**Subject: 421 Warren Avenue  
Final Site Plan Application/Delegated Review Stormwater  
Conformance with Standards  
Comment Response #3**

**Date:** July 2, 2014  
**To:** Chris Pirone, Portland Fire Department  
 Jean Fraser, City Planning  
**From:** Steve Bushey, P.E.  
**Subject:** 421 Warren Avenue, PH Warren Avenue LLC applicant  
 NFPA 1 Review to Access and Other Fire Department Issues

Job: 421 Warren Avenue

RE: April 30, 2014 Fire Department comments

REV	DATE	DESCRIPTION	REVISIONS
3	07.03.14	FINAL PLAN SUBMISSION TO CITY PER CONDITIONS OF APPROVAL	
2	04.17.14	FINAL PLAN SUBMISSION TO CITY	
1	02.10.14	SUBMITTED TO CITY OF PORTLAND

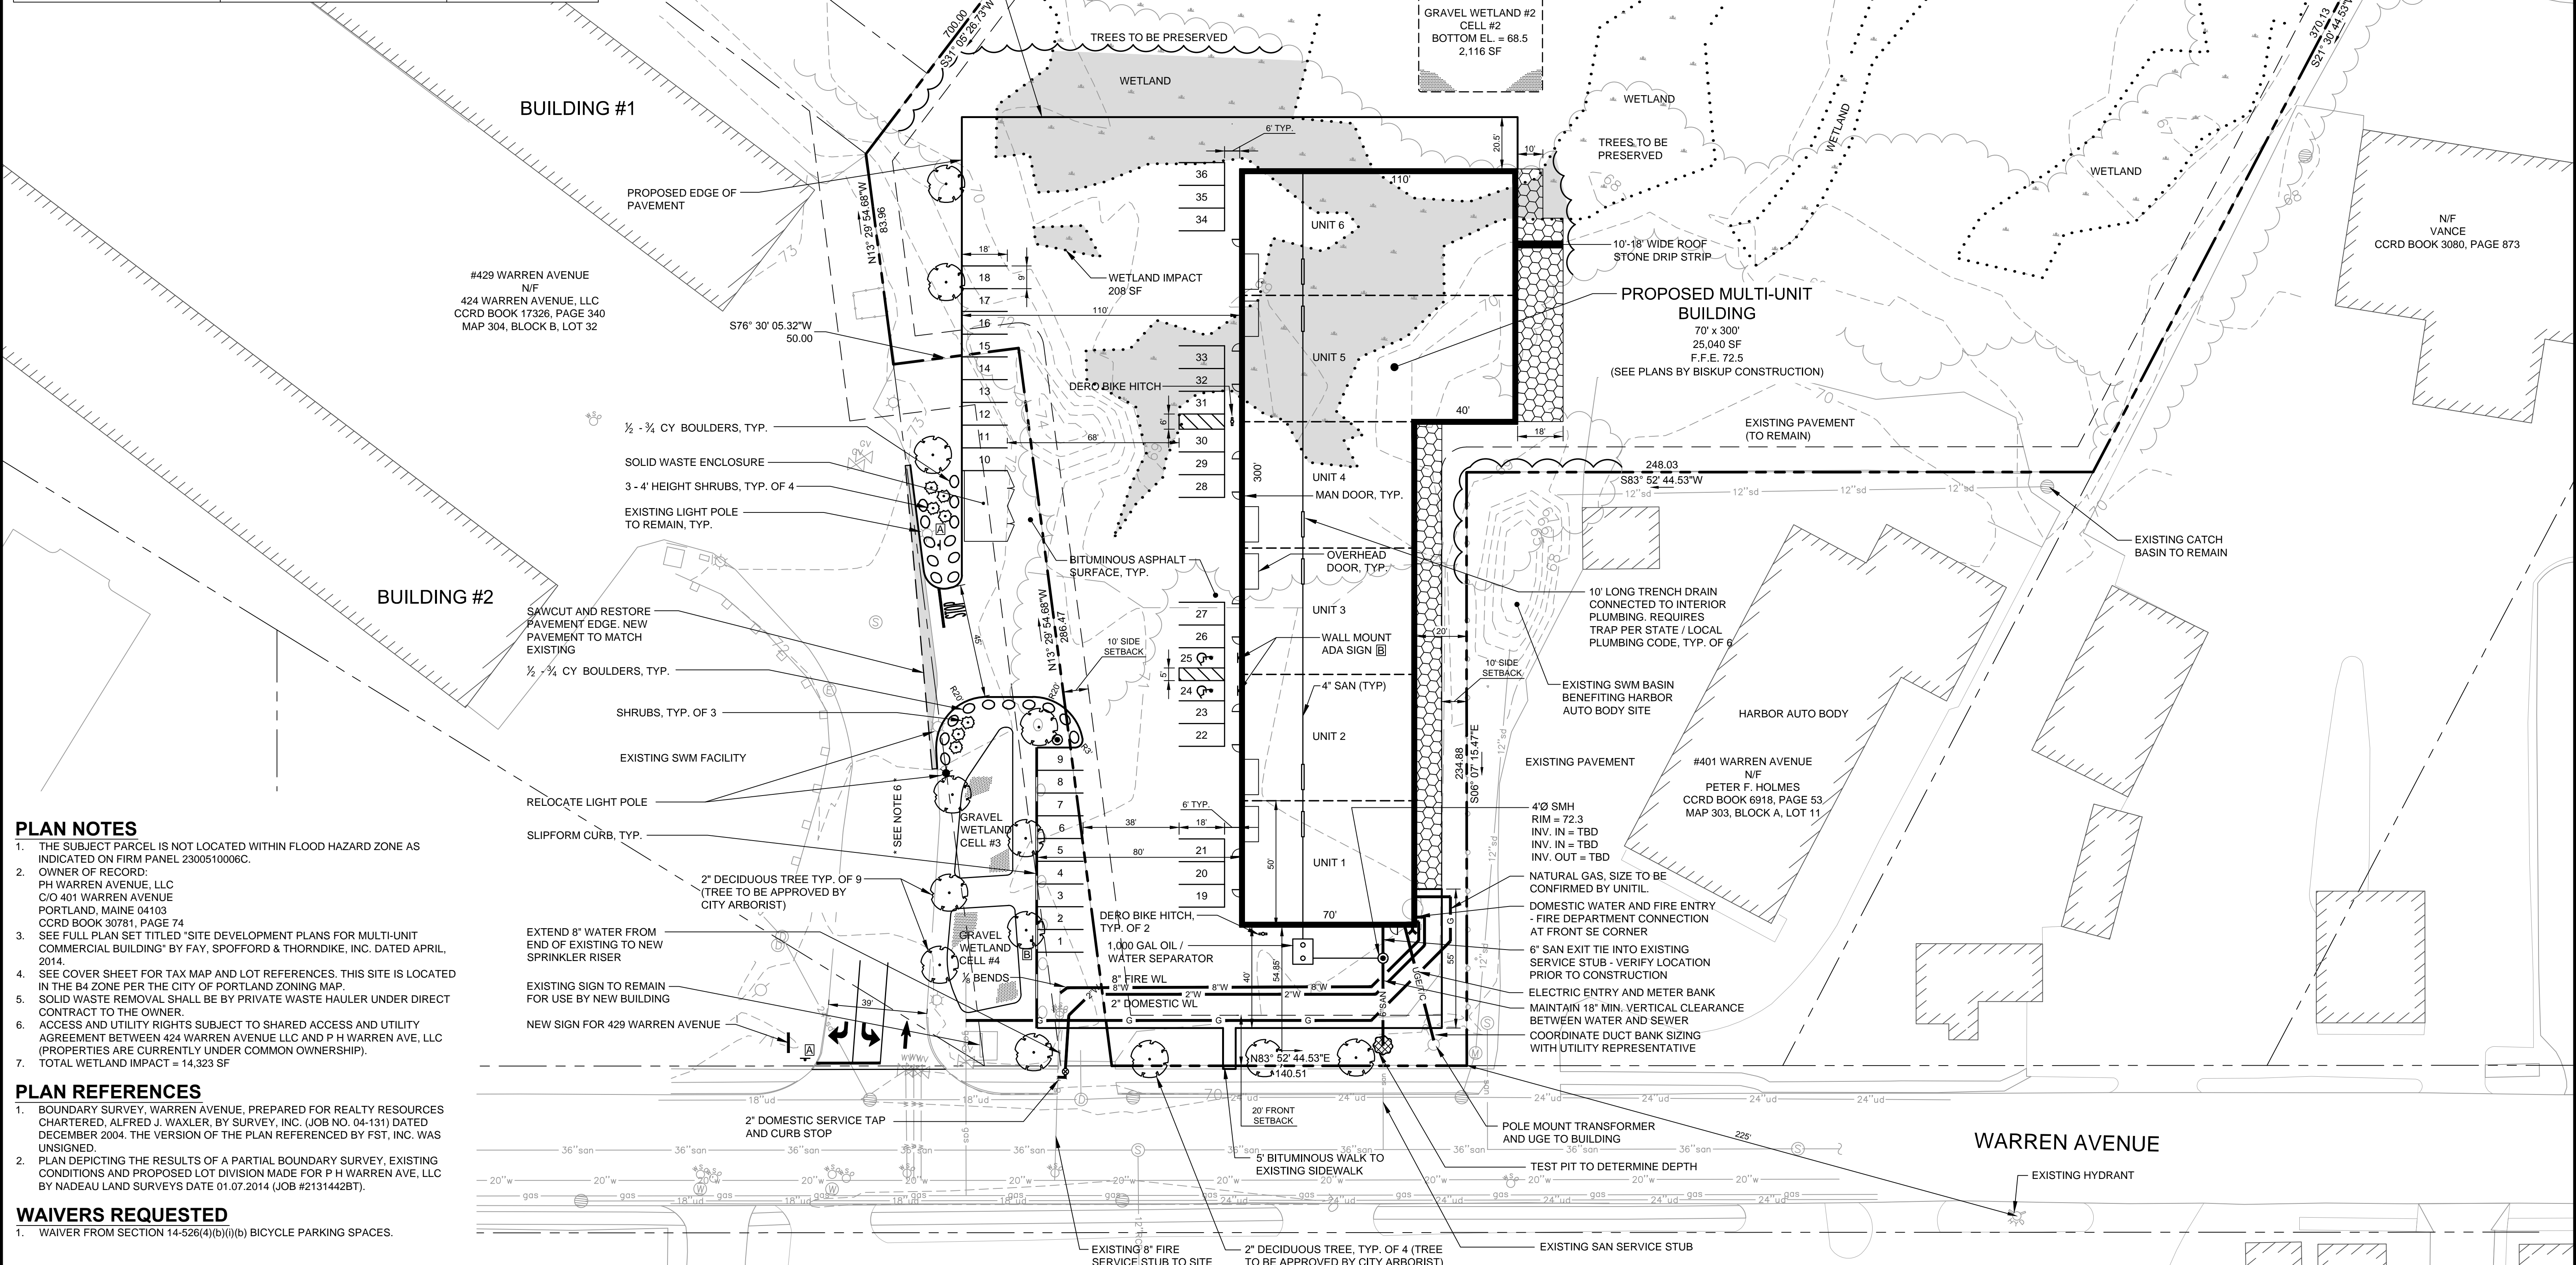
*That the applicant shall submit a Landscape Plan, based on a submitted assessment of the trees on the site, that shows the following: tree saves; any required replacement planting; and additional planting; snow storage areas; all to address the landscape preservation and parking lot landscaping requirements of the Site Plan Ordinance (14-526), for review and approval by the Planning Authority and City Arborist; and*

*Comment 1: Is the 20' access at the rear of the building being proposed for the Fire Department?*

*Comment 2: The fire Department connection for the sprinkler system will need to be located on the front of the building and will need to have a fire hydrant within 100' of the connection but no closer than 40'.*

The accompanying plan includes additional measures intended on satisfying this condition. This includes supplemental plantings around the site.

Response: The access on the north end of the building may be used by the Fire Department, however it is mostly provided to satisfy the owner's operational needs that include plowing and building maintenance.

Response: The Site Layout and Utility plan has been modified to show the Fire Department connection at the front of the building. The nearest hydrant to the site is located on Warren Avenue approximately 225 feet from the proposed front building face. We believe that this location satisfies NFPA standards that require a hydrant within 250 feet of the property line. We have discussed this condition with Mark Cummings of Fire Risk Management and he agrees with our assessment.
